Online Comment

Application H20-0060-24
Location Land adj. Havencombe Chapelgate Sutton St James PE12 0EF
Proposal Details of verification report (Condition 6 of H20-0296-23)

Name Sue Armour
Address Team Leader Environmental Protection SHDC

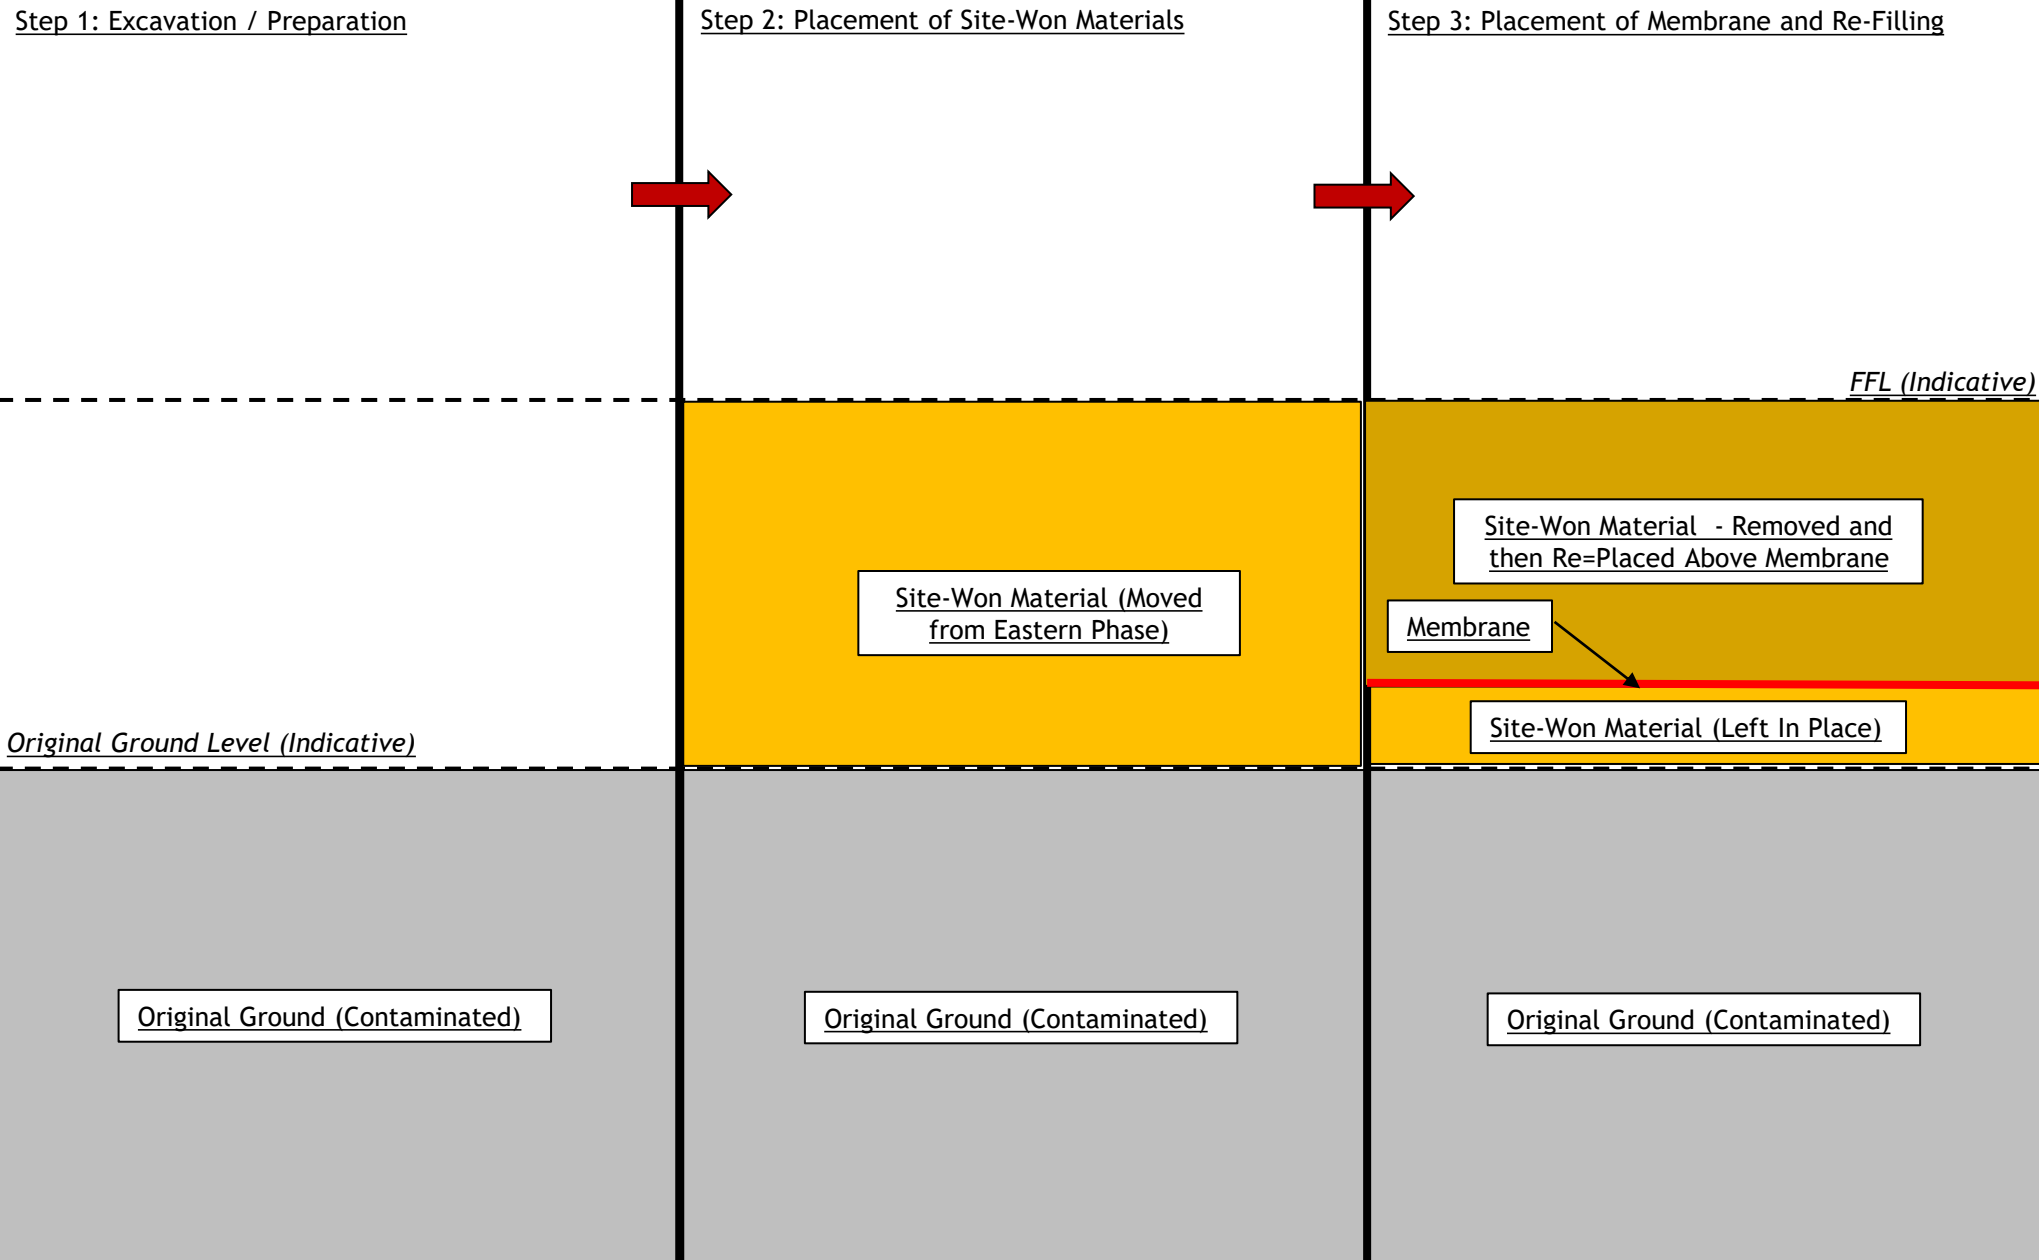
Membrane placement - the letter suggests that unsuitable material has been removed from garden areas and clean fill (Material A) placed. This (Material A) will now be removed, the membrane laid and suitable clean fill will be reinstated to finished levels.

I request that any validation report be very clear on the fate of Material A. As this has been laid directly over the unsuitable soils, there is likely to have been cross contamination. If its proposed to use Material A as the suitable clean fill to make up the final levels, any pre-placement sampling and testing would need to give a high degree of confidence in their suitability for use. A similarly high degree of confidence would need to be provided that the material management was adequately supervised, ideally by the independent consultant. I look forward to receipt of the validation reports in due course., but am not in a position to recommend discharge of condition 6 at this time.
